STATE OF NORTH CAROLINA
DEPARTMENT OF TRANSPORTATION

July 19, 2024

Subject: Request for Modification to Individual Section 404 Permit and Section 401 Water Quality Certification for U-2579 AA and AB, the Winston-Salem Northern Beltway (Eastern Section of Future I-74), from US 311 to I-40; Federal Aid Project No. NHF-0918(14), Division 9. Debit \$570 from WBS No. 34839.3.GV5.

PROJECT REFERENCE NO.	SHEET NO.
U-2579AA	5
R/W SHEET NO.	
ROADWAY DESIGN ENGINEER	HYDRAULICS ENGINEER
DOCUMENT NOT CONSIDERED FINAL UNLESS ALL SIGNATURES COMPLETED

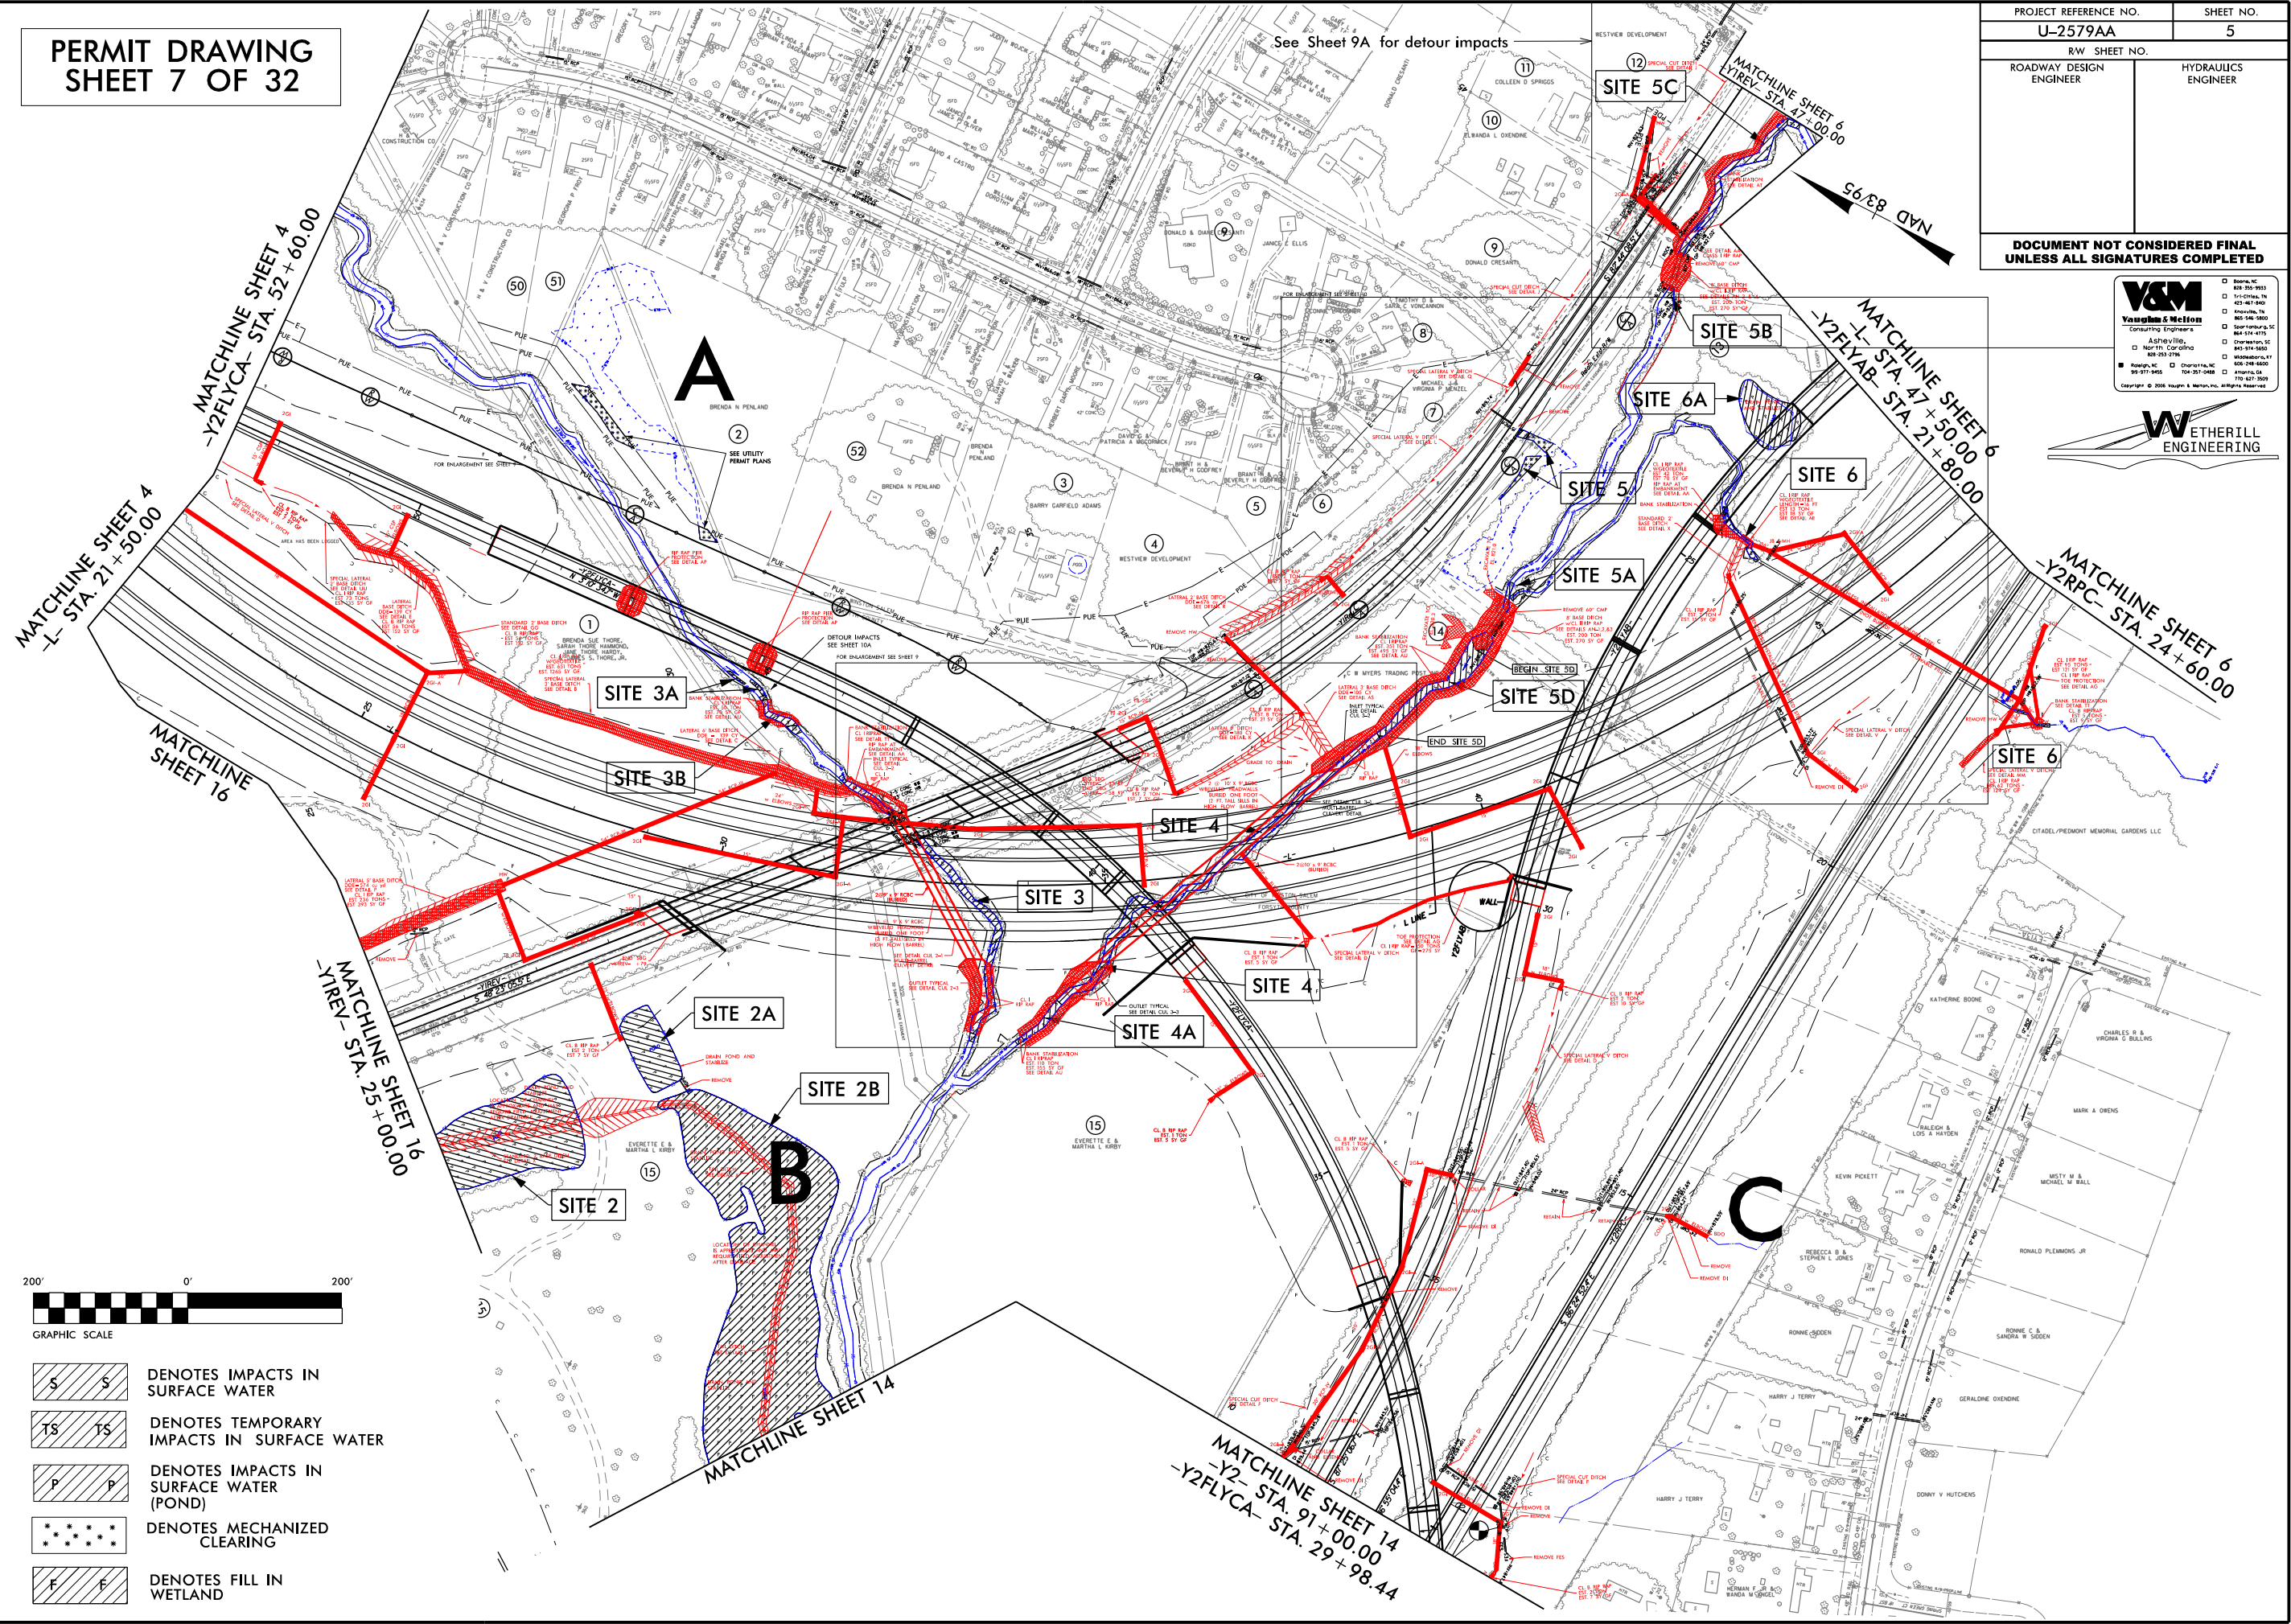
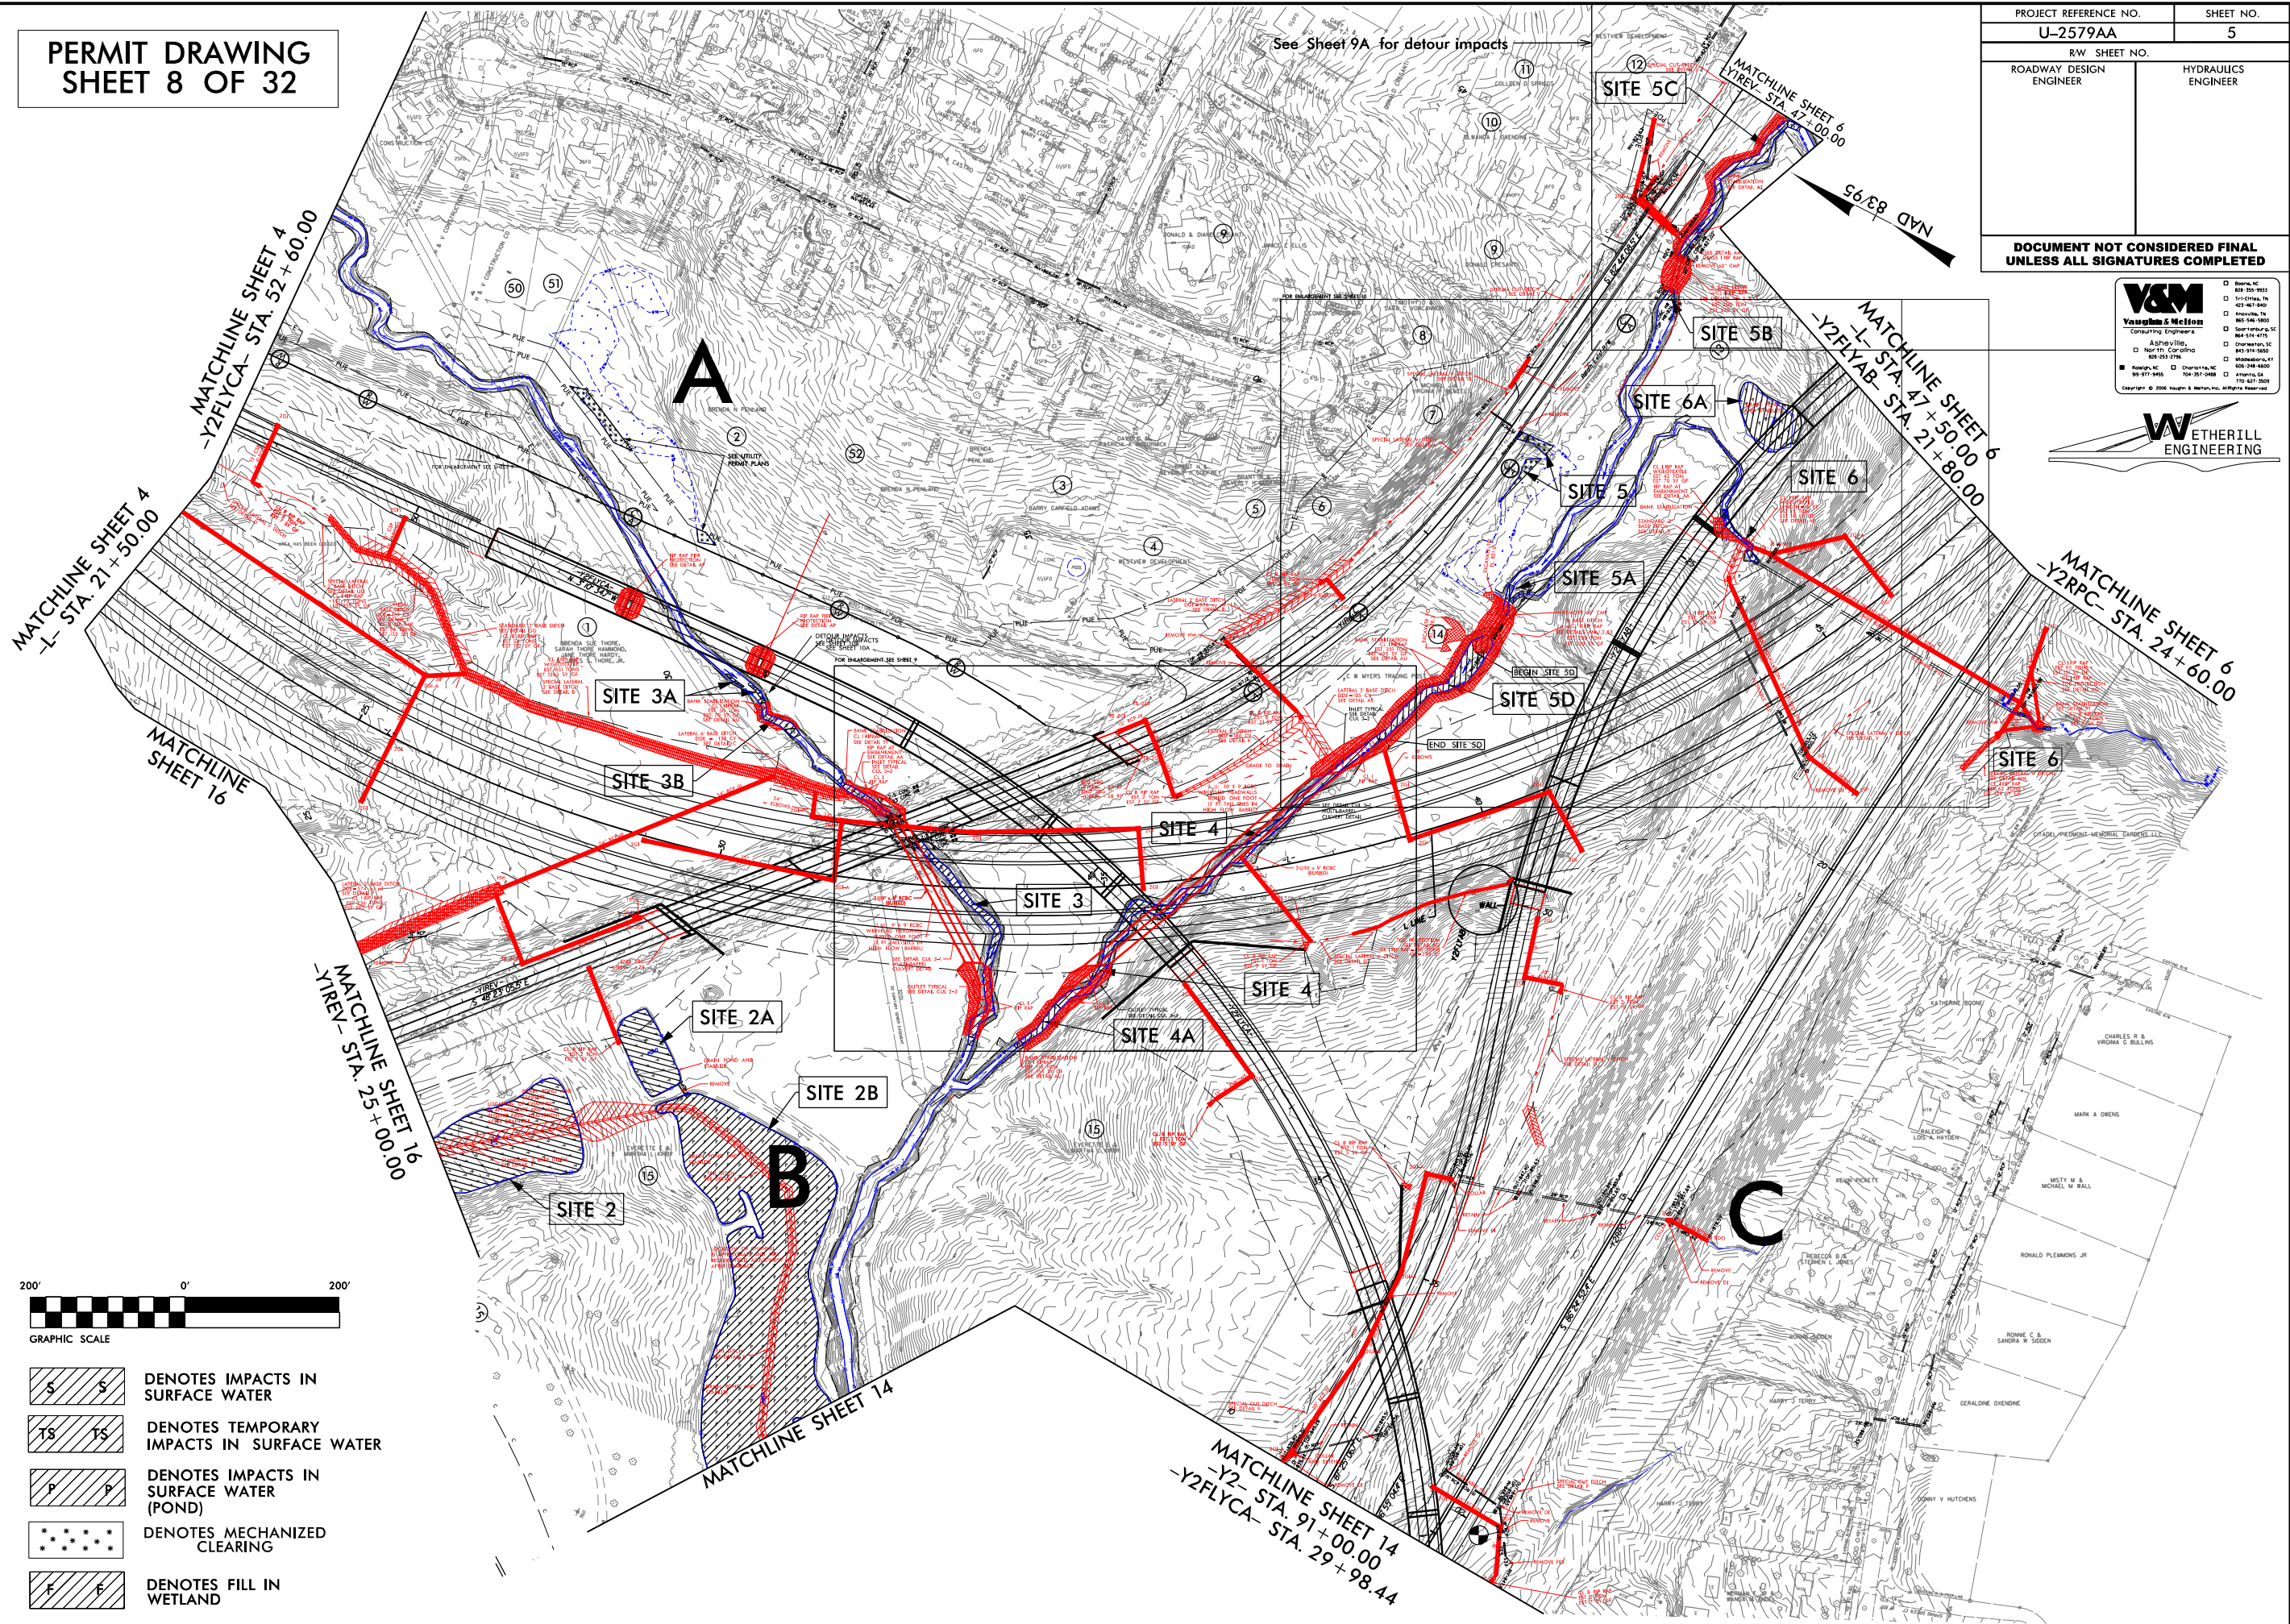
- b. Plan sheets 5 and 6 stormwater revision: the stormwater system has been revised by removing a proposed pipe system and allowing the stormwater to flow into a ditch and the crossing under the off ramp in a new 48” RCP . The stormwater will ultimately outlet at the original location at non-erosive velocities and the proposed ditches do not need to be modified to control erosion.
